Section 96A of the Town & Country Planning Act 1990 (as amended)
Town and Country Planning (Development Management Procedure) (England) Order 2015 (as amended) - Article 10

Application for a non- material amendment following the grant of LU/140/14/PL for omission of external flat render to all elevations & addition of marley eternit cedral weather boarding to all elevations.

Camellot House, 53 Arundel Road, Littlehampton,

ELEVATIONS

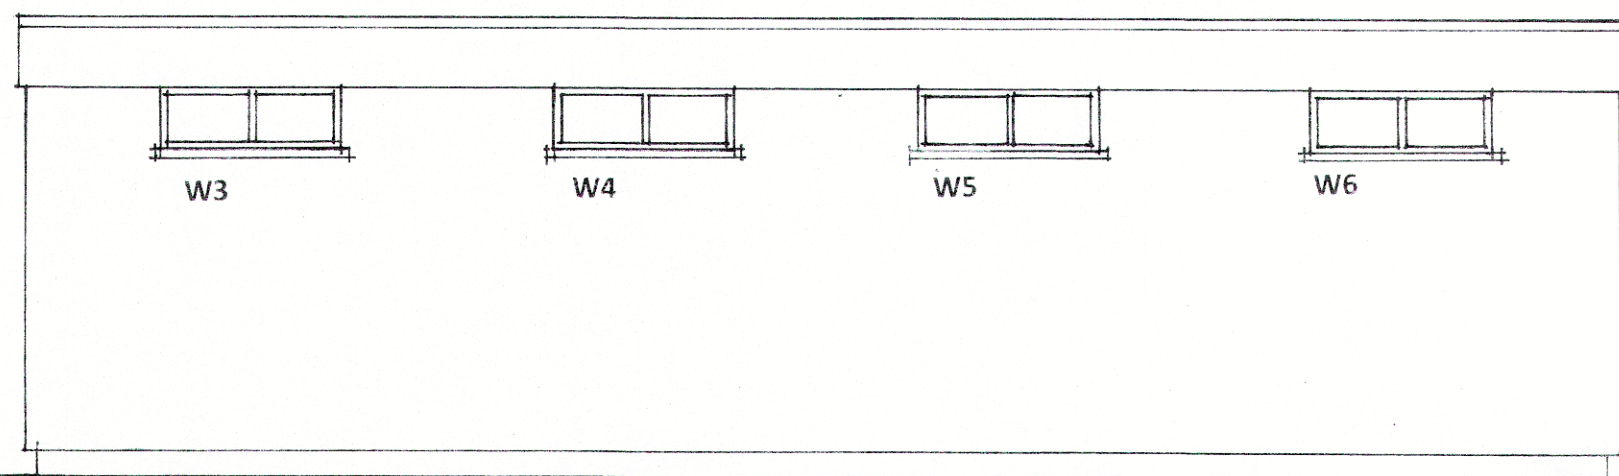
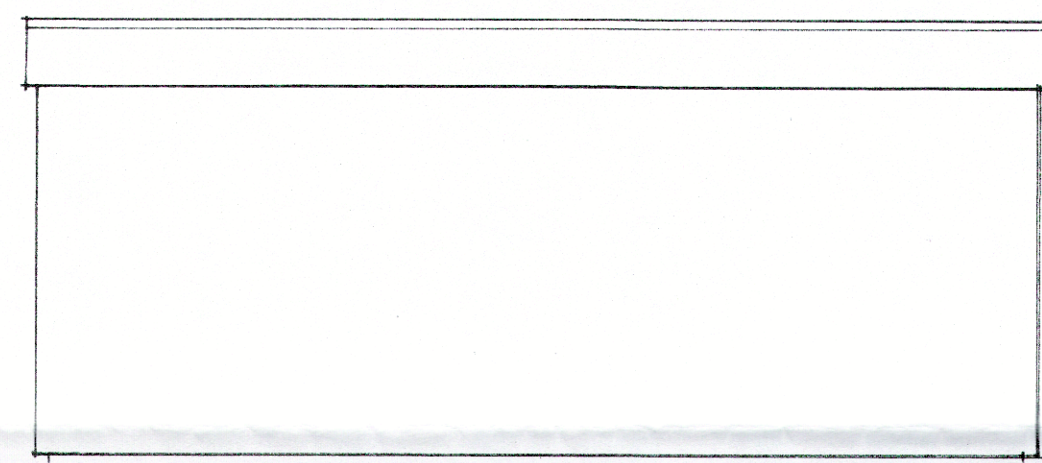
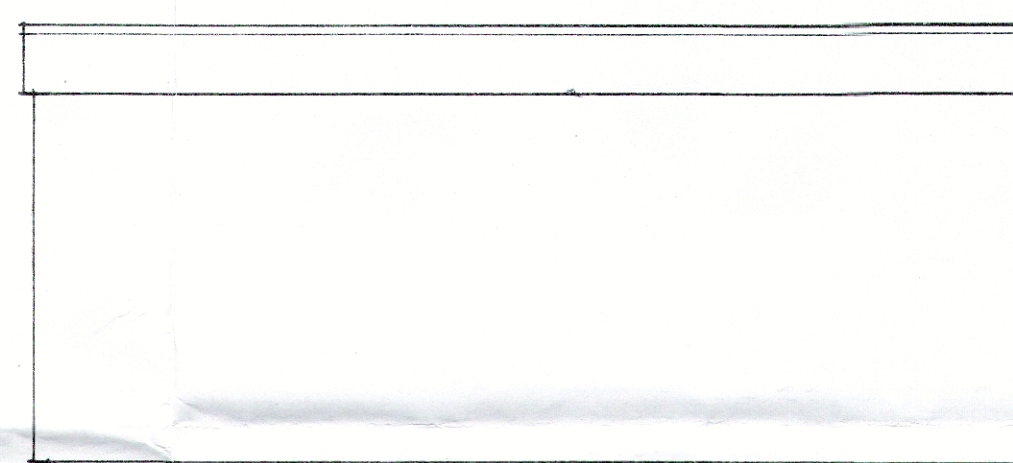
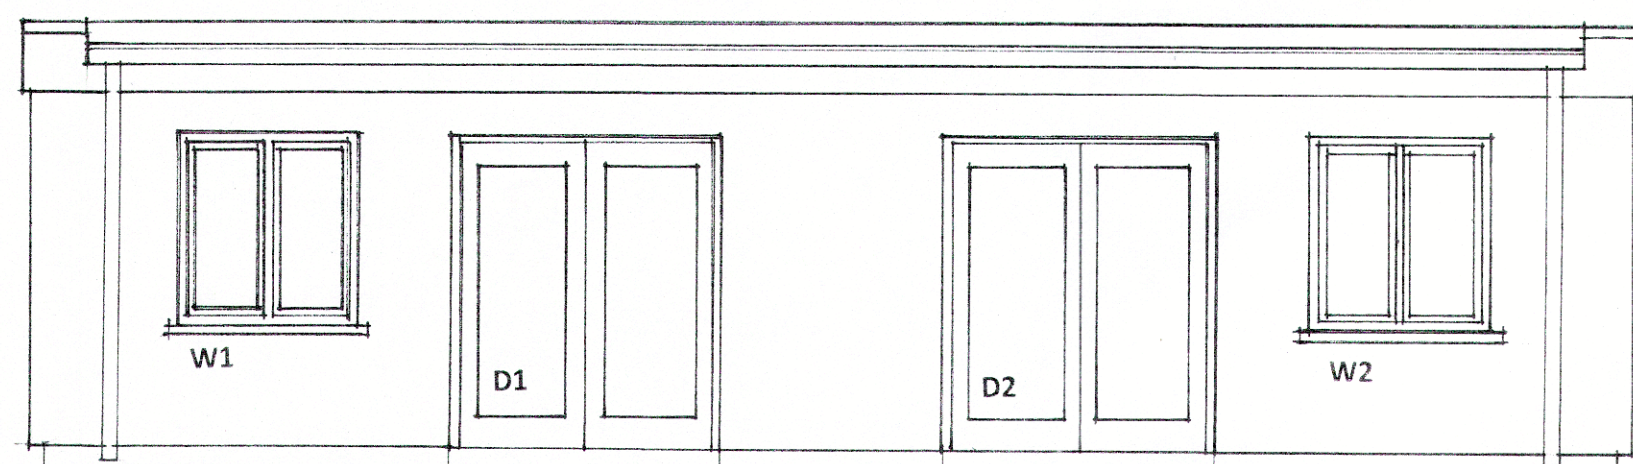
The Non-material amendment relates to the alteration of the surface material of external walls from render to Marley Eternit Cedral Weather Boarding to all elevations. These amendments are specified on drawings;

Proposed Elevations Dwg.no. 3035-004A

Therefore, the proposed details are accepted as a Non-material amendment and now become the approved details for LU/140/14/PL.

Drawing Title
GROUND FLOOR PLAN + SECTION

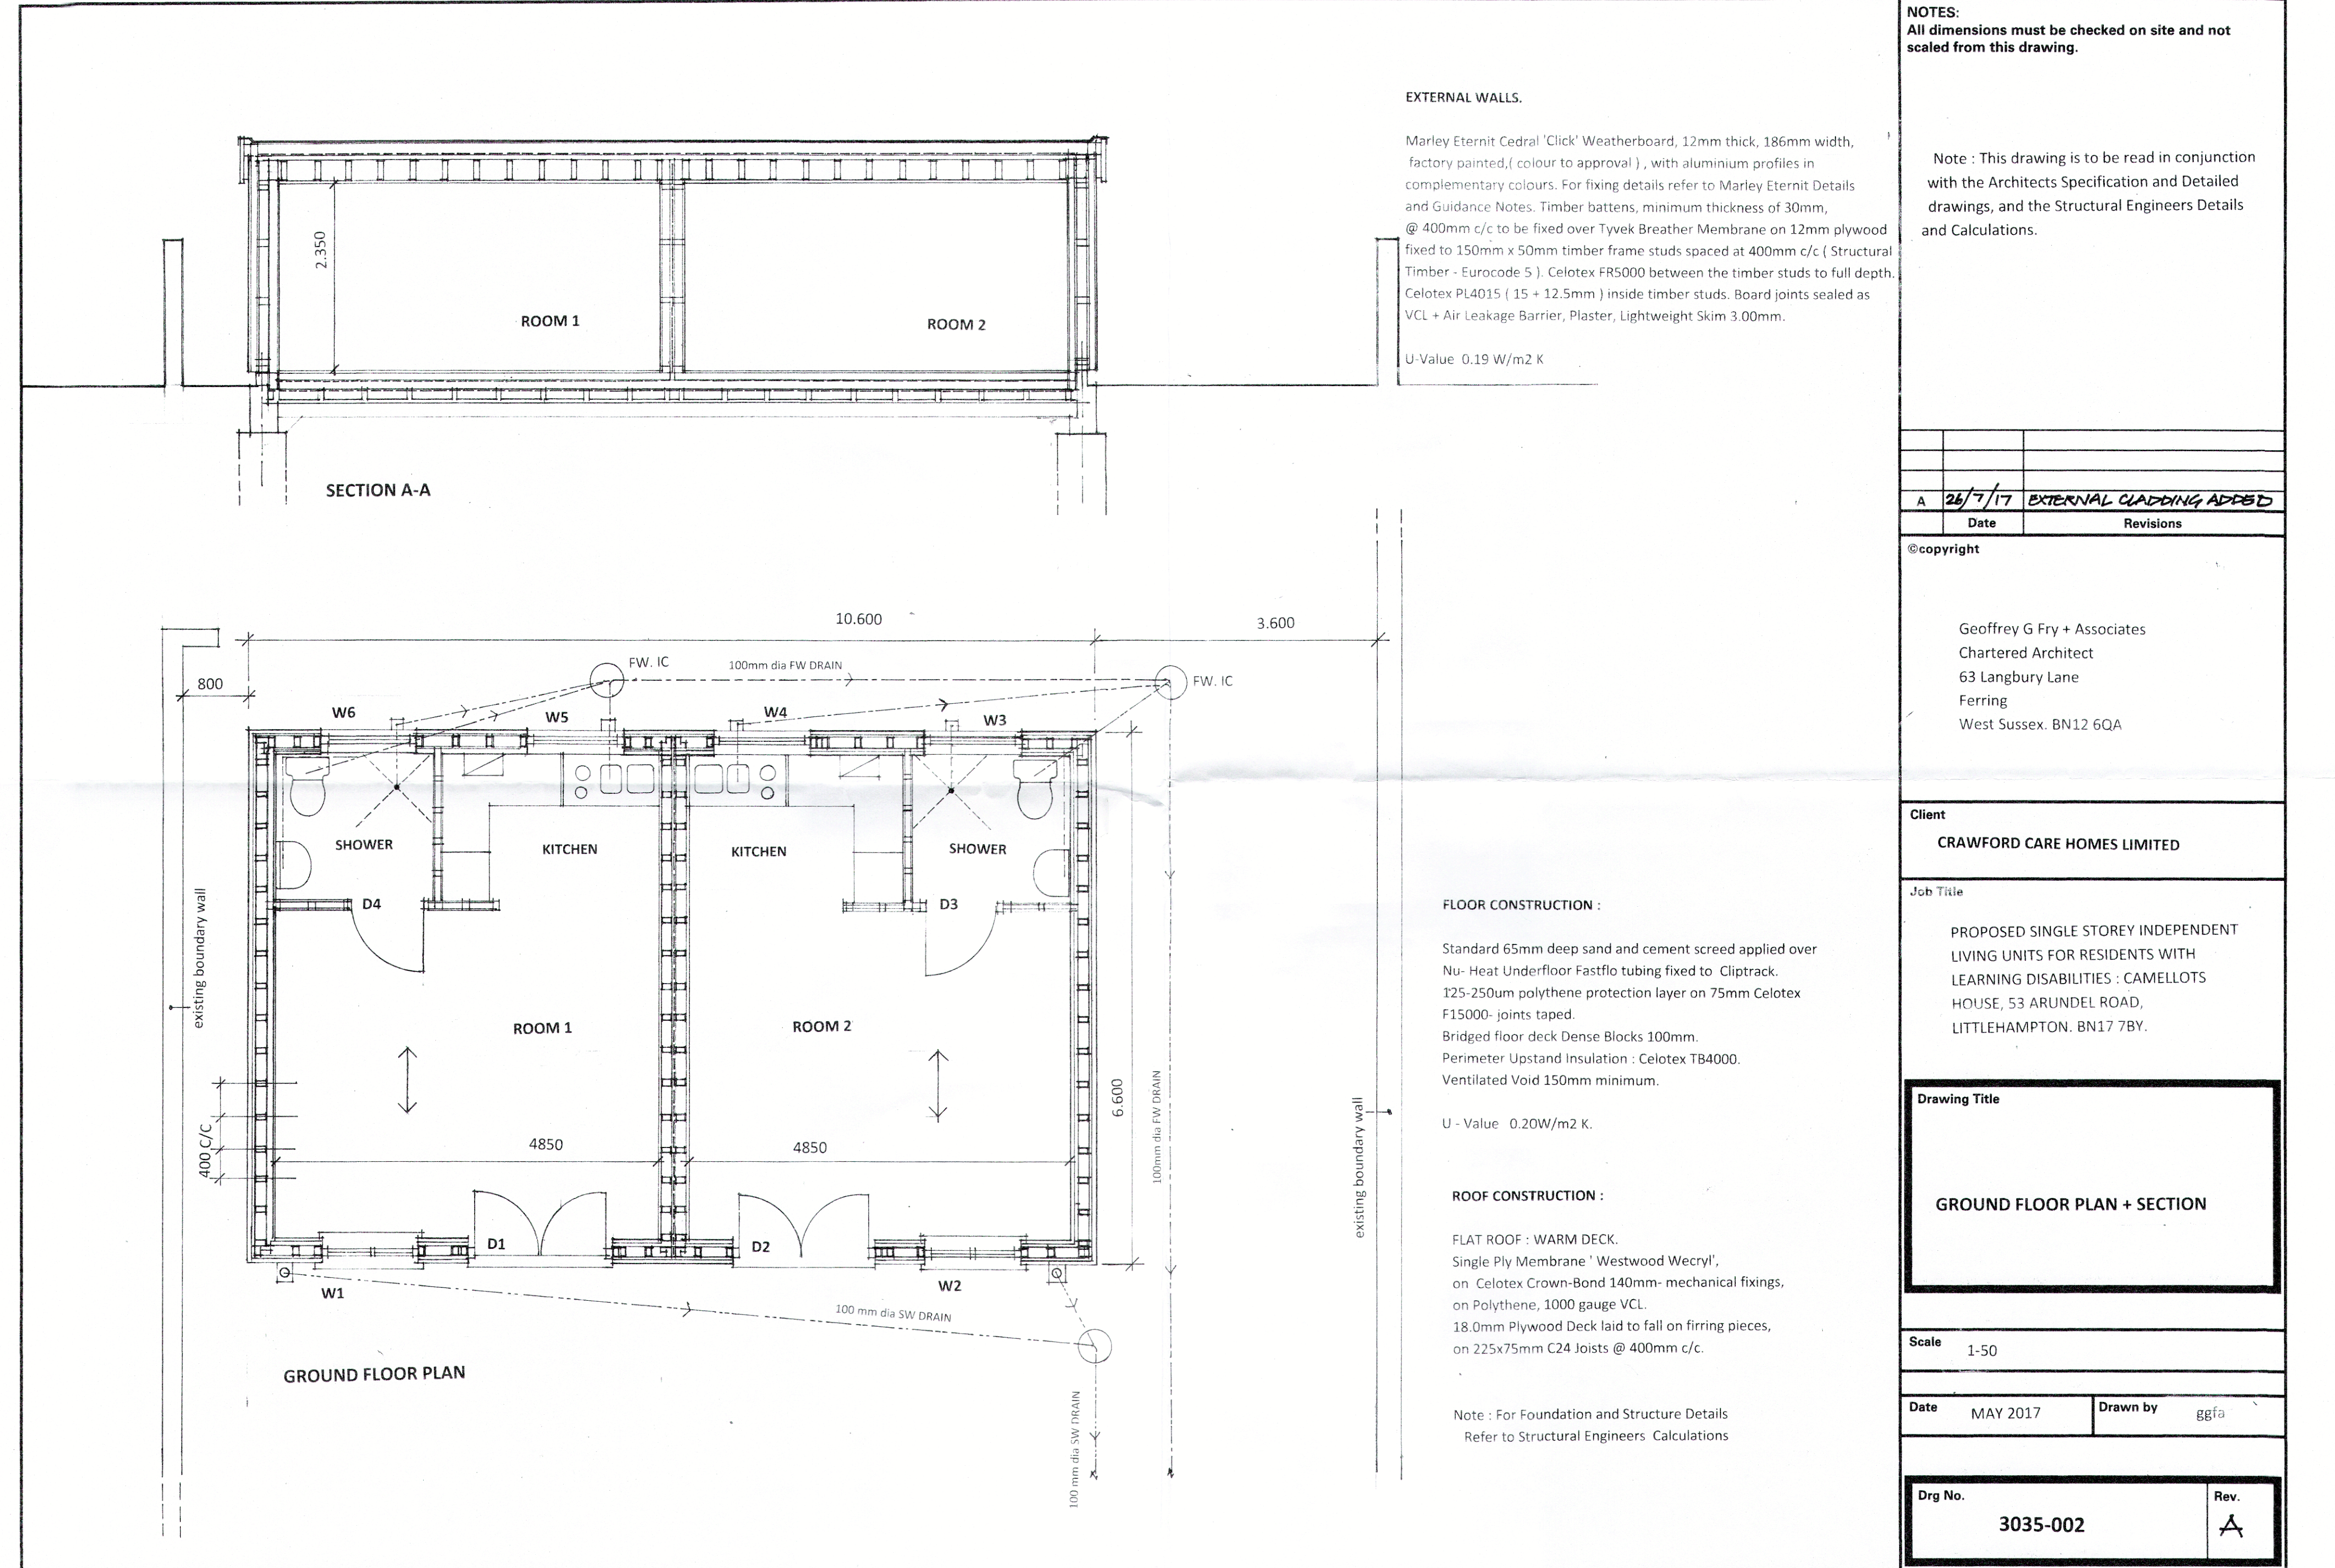
Proposed Floor Plan and Sections Dwg.no. 3035-002A
